Application for Planning Permission

Development: Development of a 5m screening wall to western perimeter. This application is in CIL Zone 3 (Zero Rated) as other development.
Location: Land At Northwood Farm Yapton Road Climping BN18 0HR

Location Plan

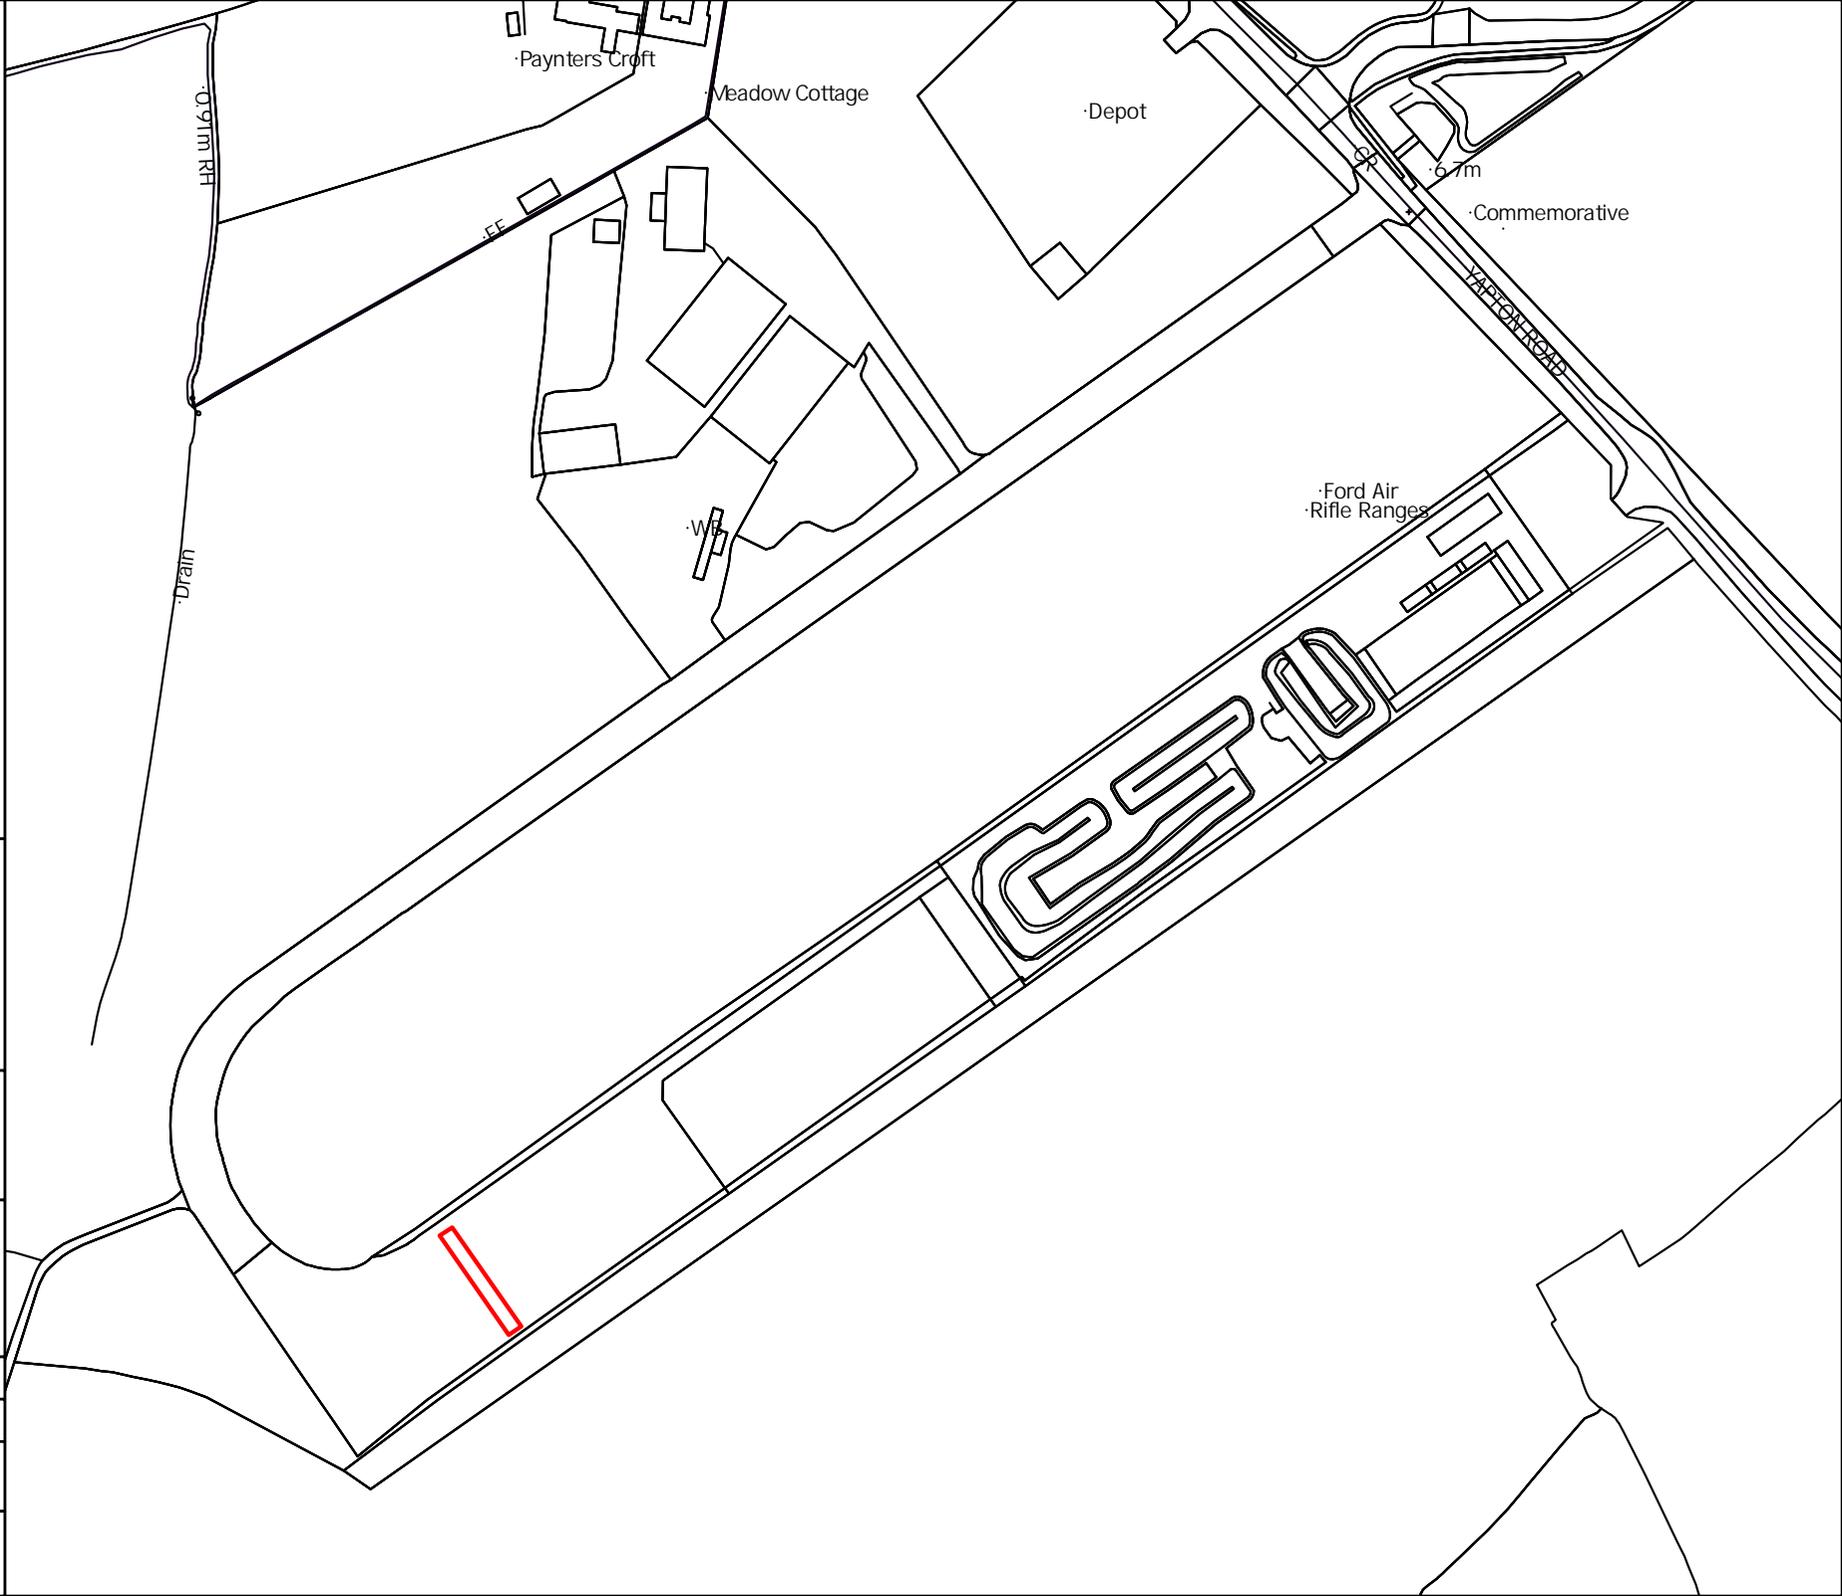
Location Plan

Please submit an electronic location plan in pdf format at a scale of 1:1250 or 1:2500 for rural areas. Further details of what must be included on the plan can be found in the Validation Requirements List.

Block Plan

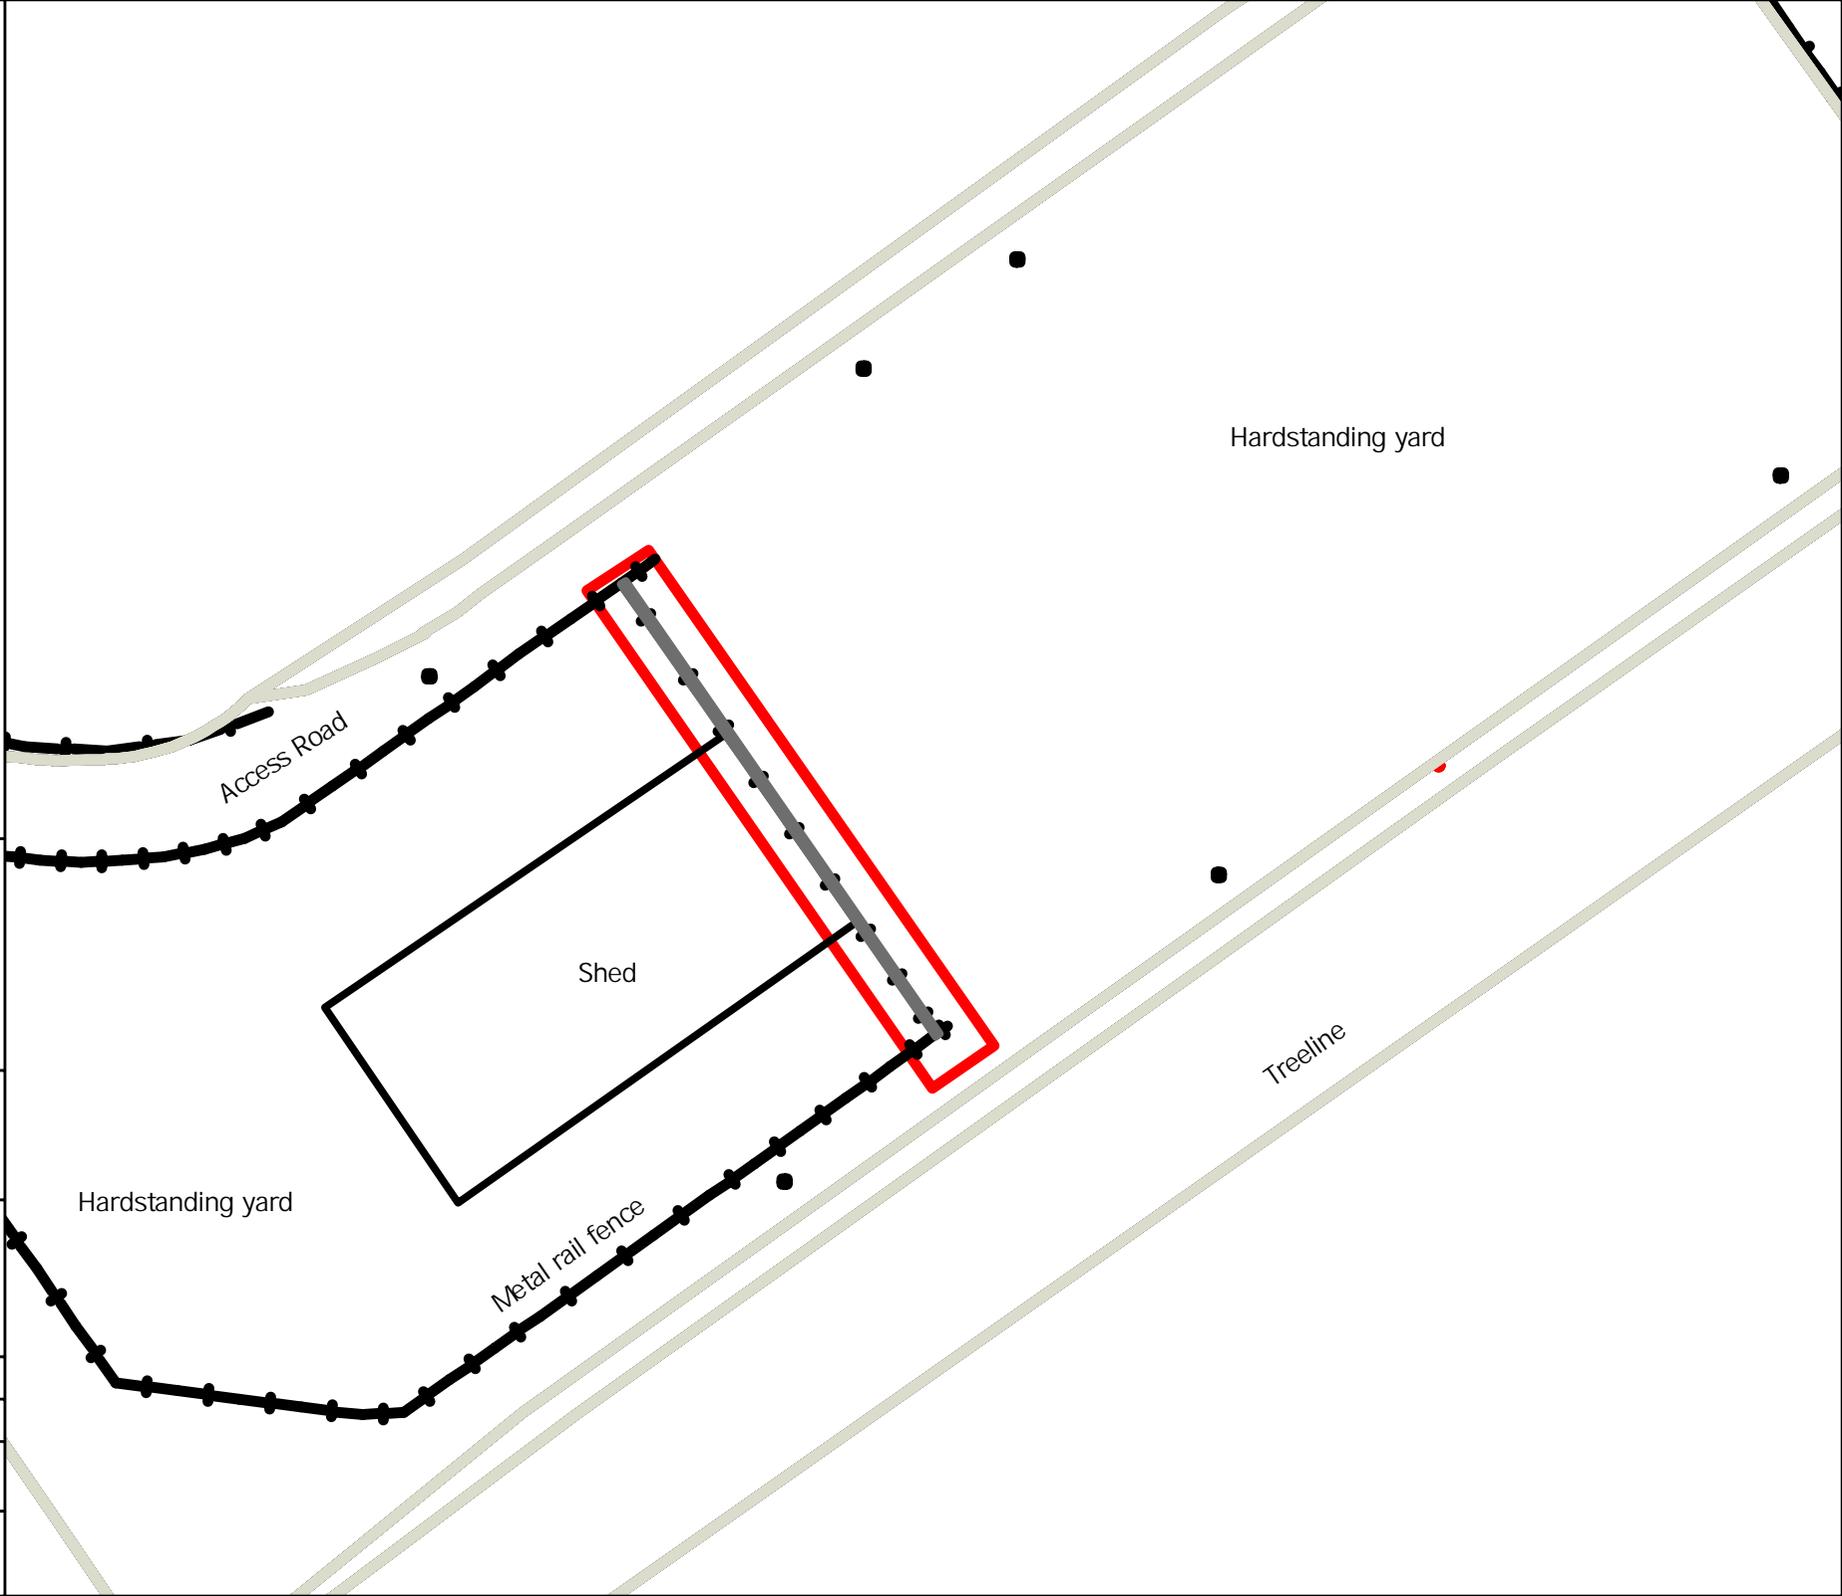
Block Plan

Please submit an electronic block plan in pdf format at a scale of 1:500. Further details of what must be included on the plan can be found in the Validation Requirements List.
